**RE: Warragamba Dam Raising EIS review - Production Ave Impact**

Simba Developments PTY LTD (Simba), a company of the Allam Property Group, is an adjoining property owner over the former African Lion Safari Park (ALSP) which has frontage to Production Ave, Warradale Road and Marsh Road, Silverdale. Simba Developments is currently developing a total of 448 residential lots which commenced in year 2019 and is currently forecast to have works completed in late 2027 with stages 5-8 to be still developed.

- *Warragamba Dam Raising Project – SSI8441*

Figure 24-11. Property access from Silverdale Road and Warradale Road (southern route)

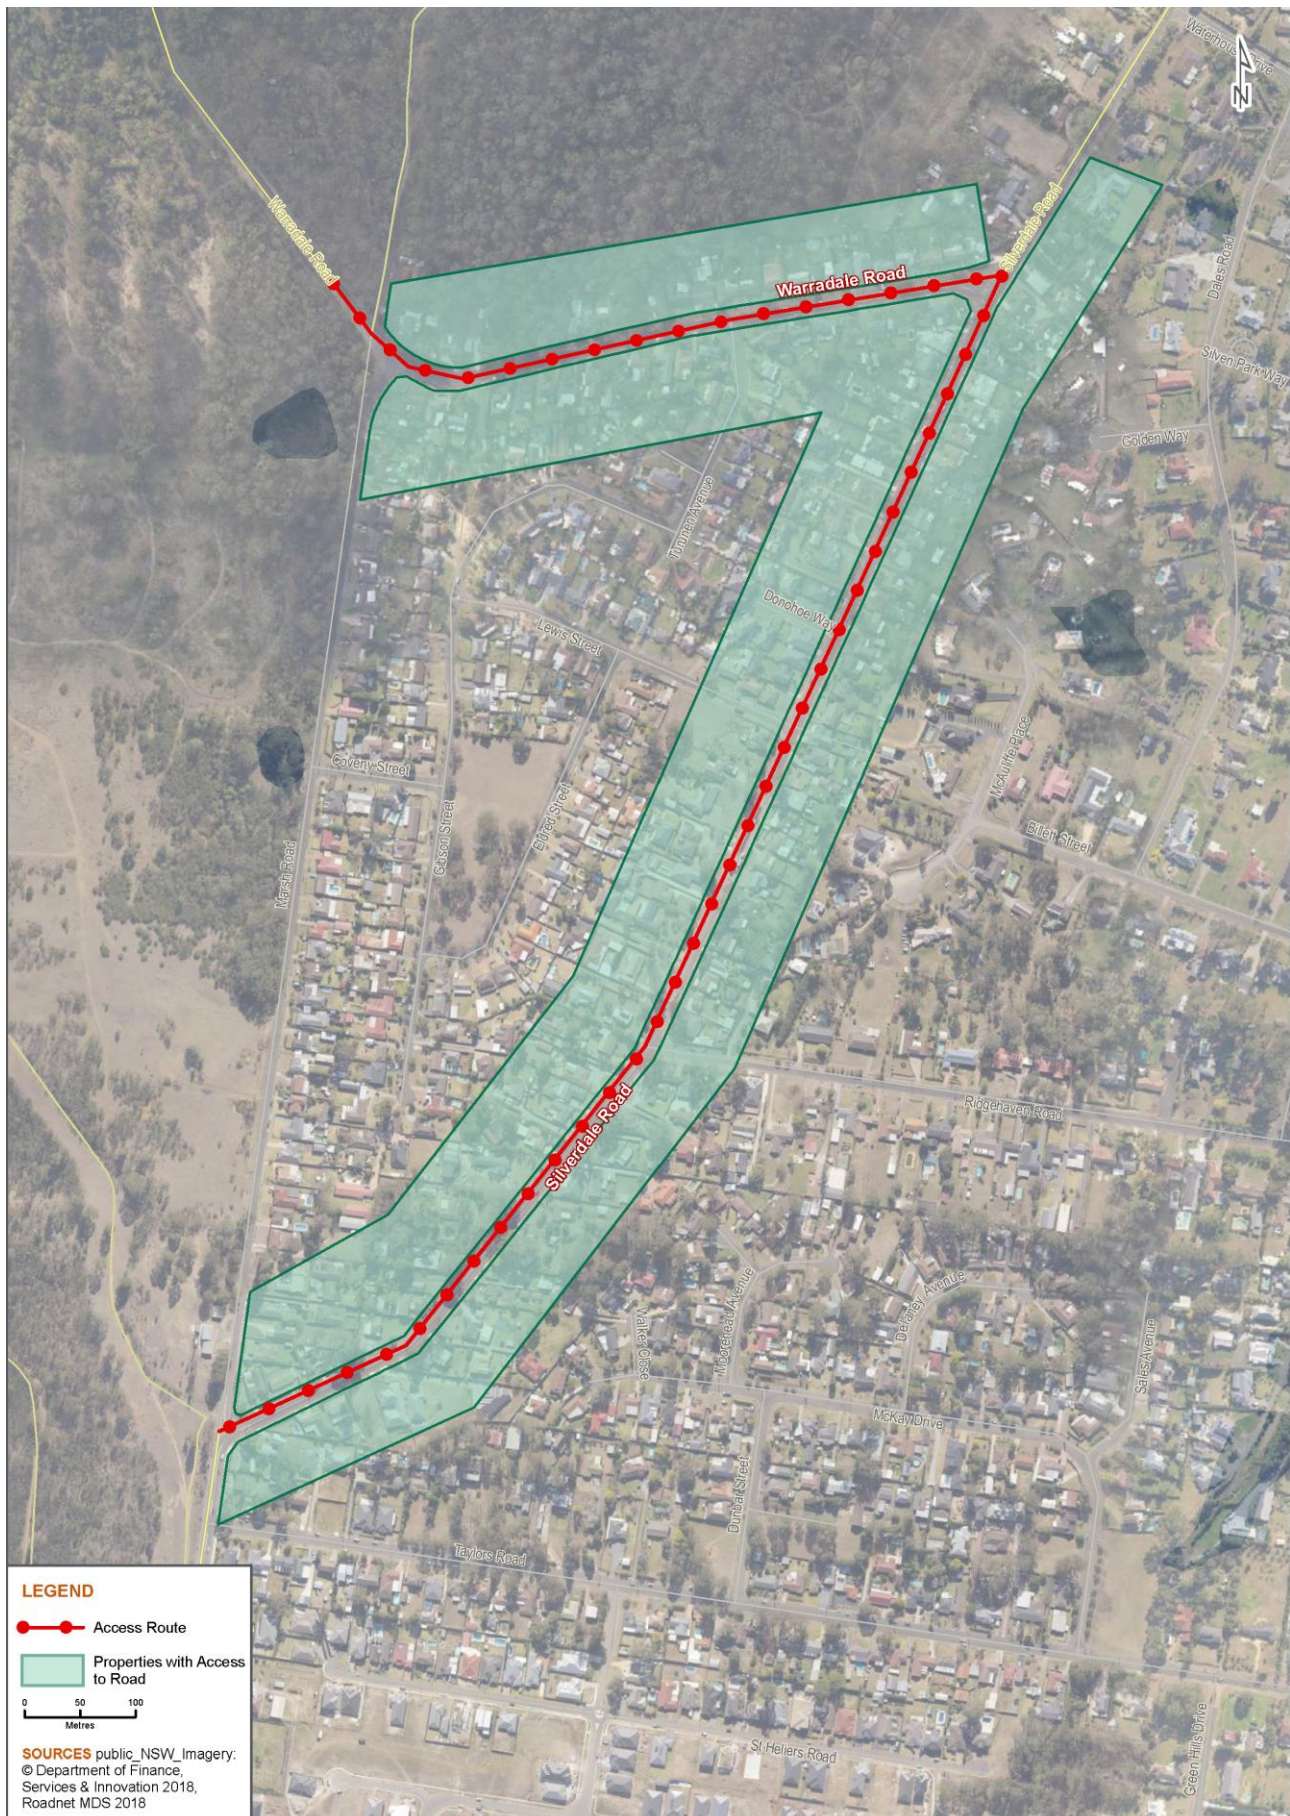
- This will restrict traffic flow and raise a safety issue whilst this crossing is being constructed or operational.
    - EIS indicates that temporary traffic lights will be installed at the intersection of Production and Warradale Roads. This may impact traffic flow with our road closures while we carry out the re-construction of Production Avenue.

Figure 24-23. Southern truck route

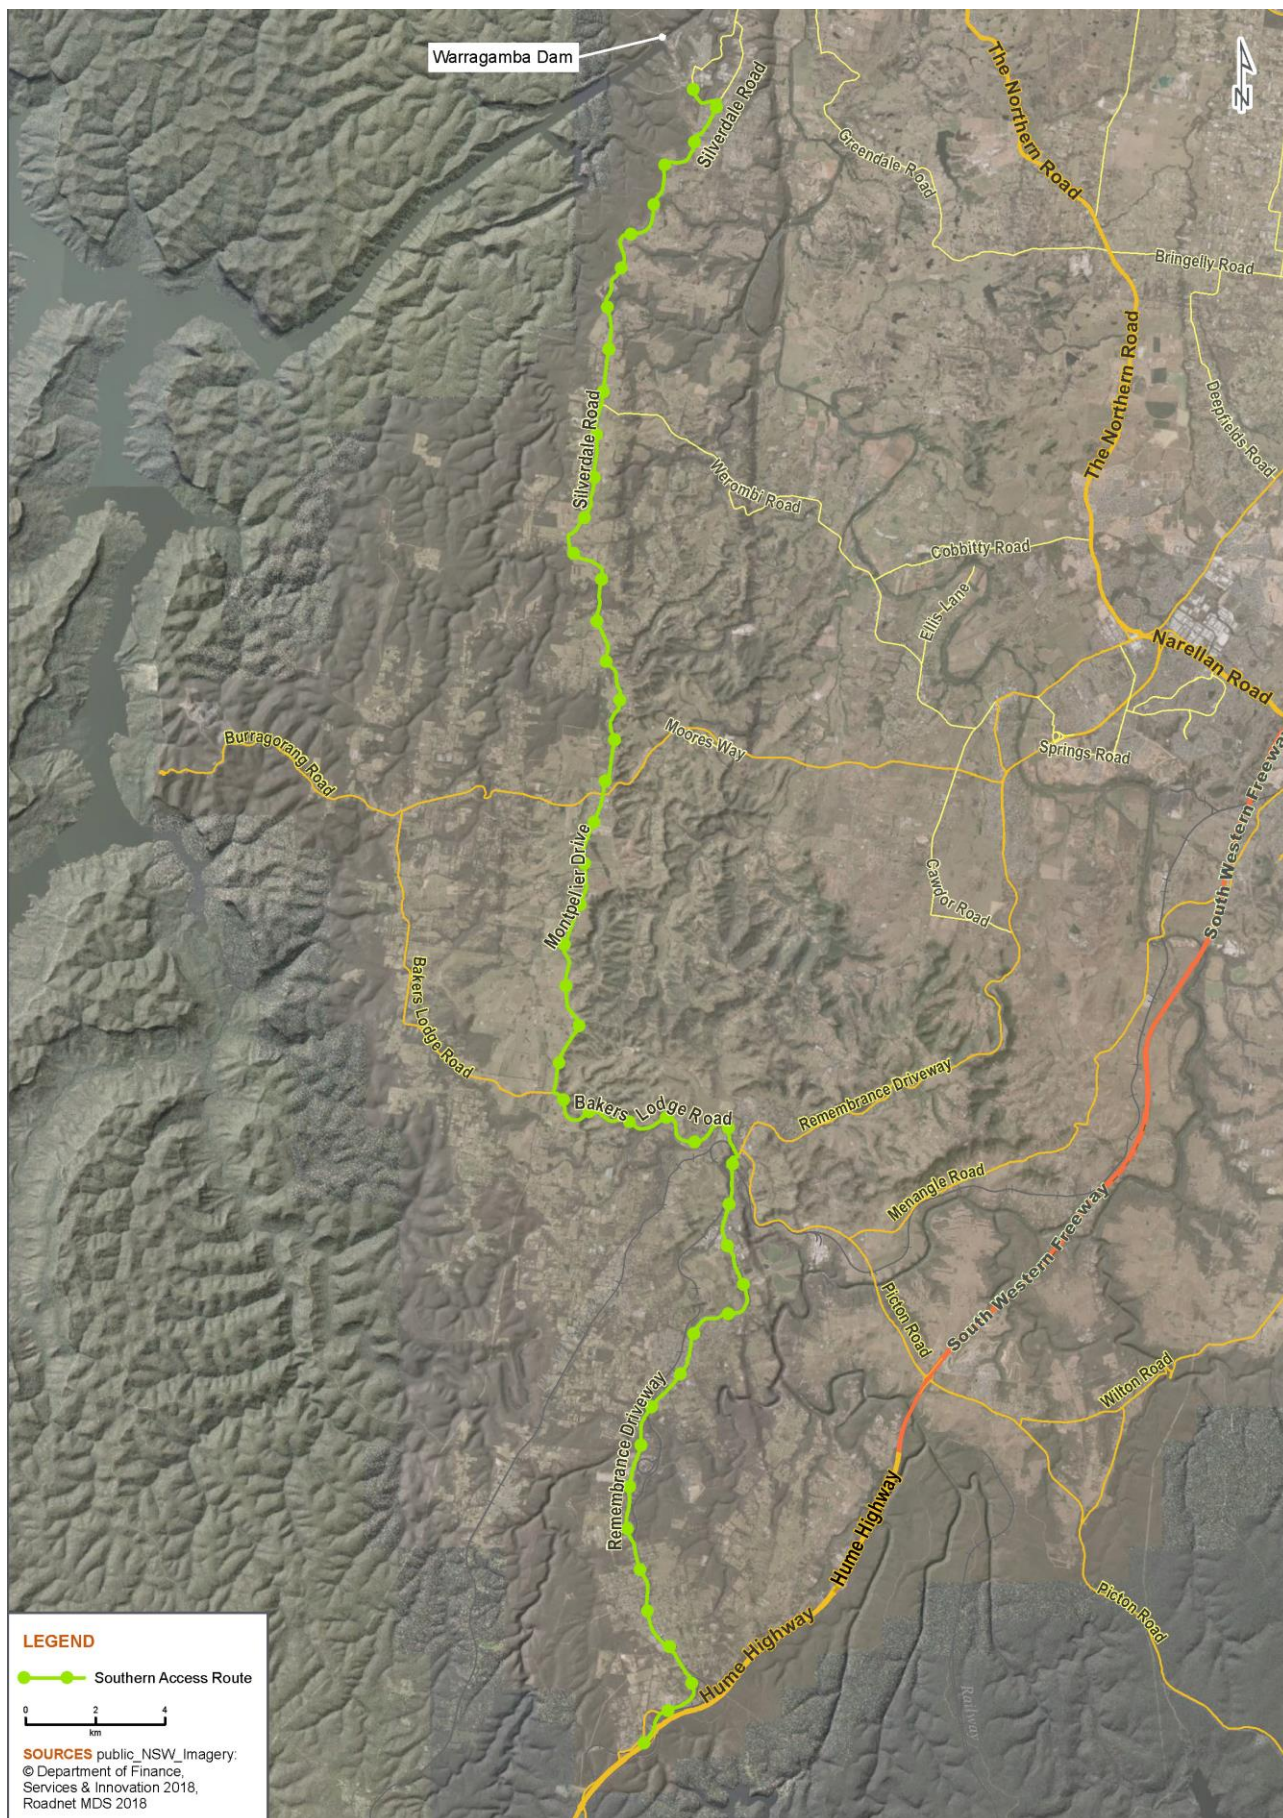
Both parties, Simba Developments and Water NSW will be impacted due to the proposed timing for the raising the dam wall. Simba Developments requires to carry out Civil and Housing works along Production Ave. The EIS is currently proposing that the vehicle movement will be along Production Ave and this may have an impact in the need of this road re-construction and possible road closures.

Therefore, our main concerns are based around the timing of the raising of the Dam wall and the vehicle and traffic movements along Production Ave and Warradale Roads. This will impact both parties during a period of up to 5 years if works overlap to construct these works. If both parties commence activities along Production Ave at the same time, this will have a major impact on the Traffic control measures if these clashes. The EIS traffic management plan should consider an alternative route so that neither party will be required to stop works.
